Application No: FP/126/25/HH
Site Address: 2 Stanhorn Grove Felpham PO22 8FP
Description of works: Conversion of detached garage to form annexe.

OWPC78819

SITE PLAN

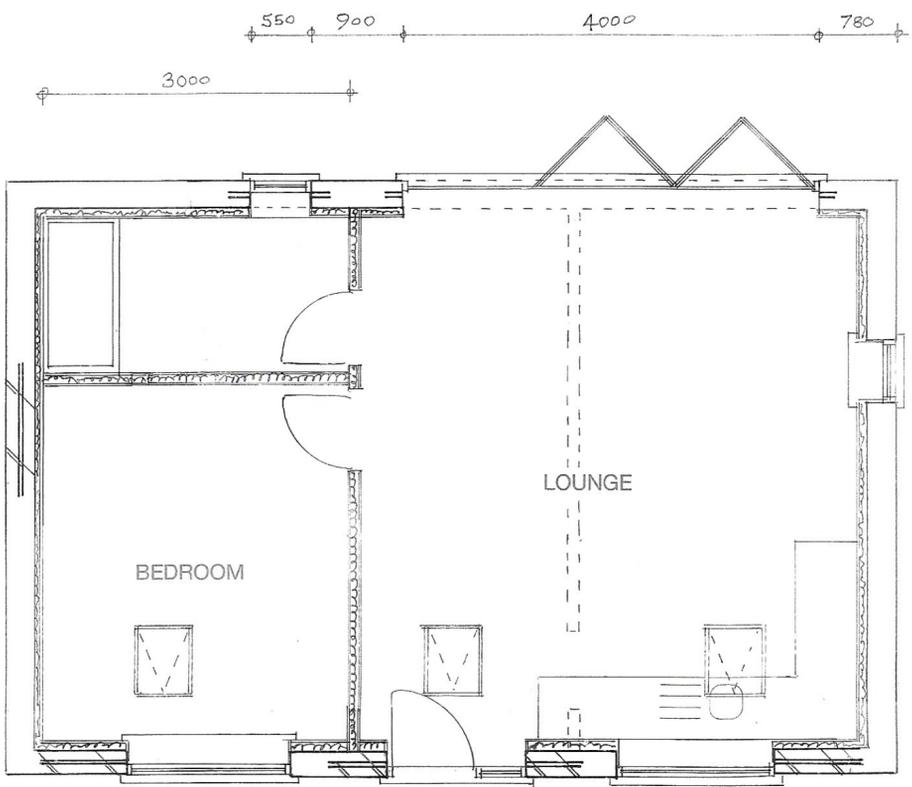
Felpham Parish Council object to this application on the following grounds:
Does not comply with national minimum space standards in the UK.
Insufficient parking on site.
Scale bars do not scale.
